Access Report

Mixed Use Development
Cnr Kenrick & Union Streets
THE JUNCTION

For: The Junction Development
Company
Ref: PAA_25231

State Significant Development Application documentation for the proposed Mixed Use Development at cnr Kenrick & Union Streets The junction has been reviewed against current accessibility legislation.

REVISION	R.10 SSDA 04.05.2026
DRAWING	FLOOR PLAN GROUND
NUMBER	A-14

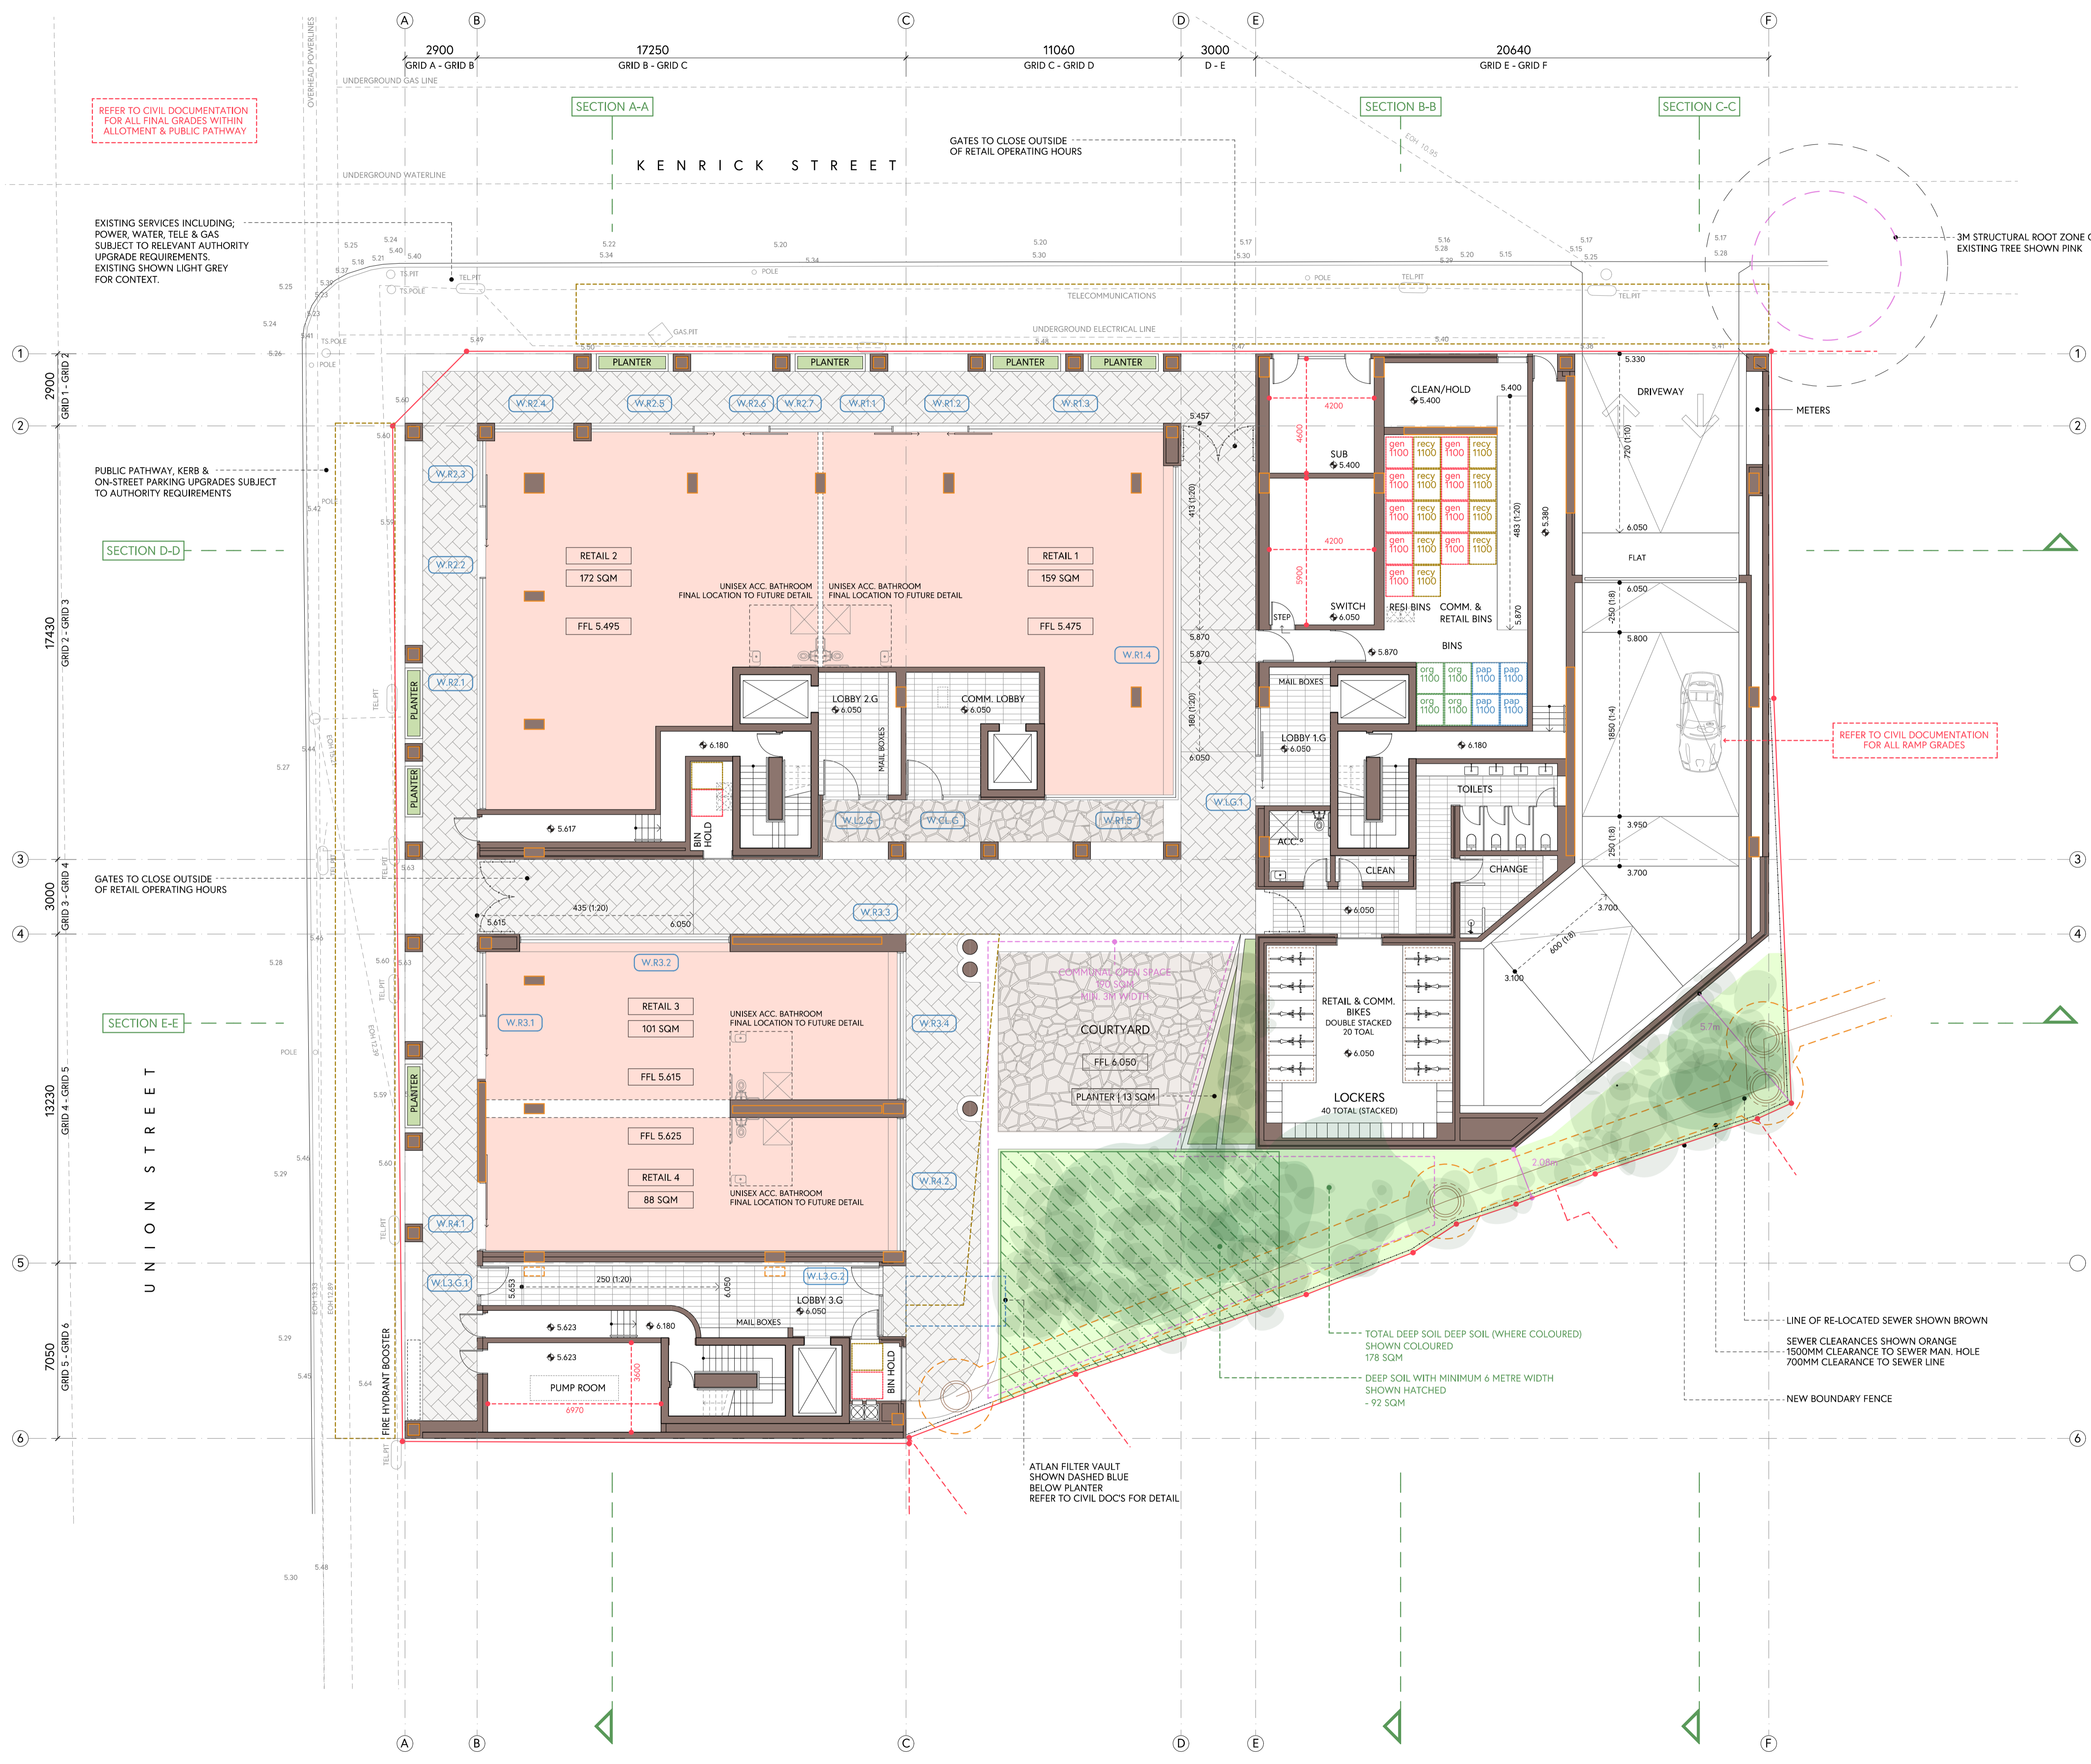
Single hinged doorways provide commercial and residential Lobbies. Compliant circulation areas are generally achieved – ensure that doorway W.LG.1 from Union Street achieves 530mm at the latch side – appears to be currently just under this.

A level threshold hold is achievable at each doorway. Ensure that the selected doors enable a clear opening width of 850mm to all entrance doorways.
